**Canal &
River Trust**

Your Ref 2026/90946

Proposal: Discharge of details reserved by conditions 5 , 6 , 7, 8 (Demolition Works), 9 (new walls/other structures), 14 (electricity substation), 18 (Phase II Intrusive Site Investigation Report), 23 (drainage), 24 (new building retaining walls), 25 (CEMP), 28 (cycles), 30 (evc), 34 (retained walls), 35 (Mitigation Method Statement), 36 (PWMS), 37 (CEMP: Biodiversity), 38 (BEMP), 40 (security and crime prevention measures), 41 (landscaping) on previous permission 2025/91122 for Redevelopment of site for mixed-use E(g) (i, ii and iii) and B8 including: demolition of buildings and re-cladding of southern elevation of retainer adjoining building; retention, conversion and renovation of existing mill/office/workshop/engine house building including alterations; erection of two new buildings; formation of two vehicular access points, service yard and parking areas; and other associated works

Location: J L Brierley, Turnbridge Mills, Quay Street, Huddersfield

Drawing Title
External Lighting Layout

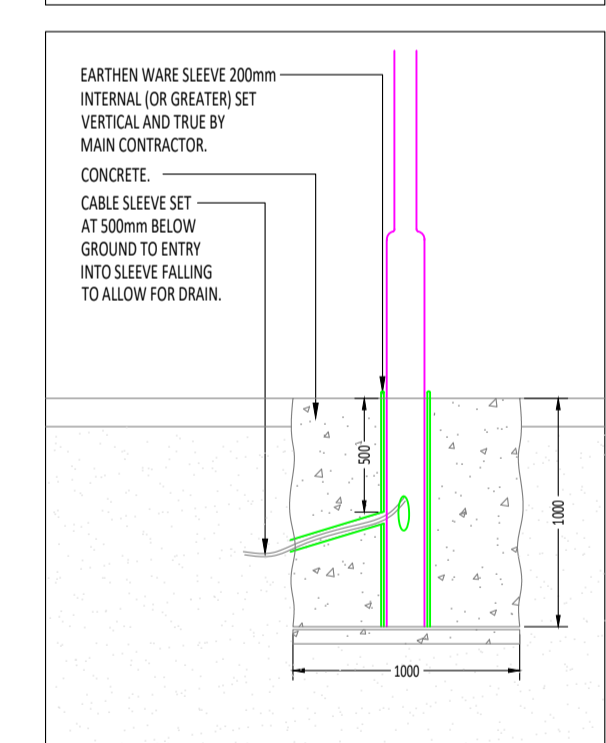
We note that the proposed security measures include security lighting which would involve light spill onto the canal corridor. The canal is a potential habitat for bat foraging and commuting, which could be disturbed by significant light spill.

Taking account of expert advice as necessary, we request that the Local Planning Authority satisfy themselves that the proposals will not cause harm to potential bat populations in the local area.
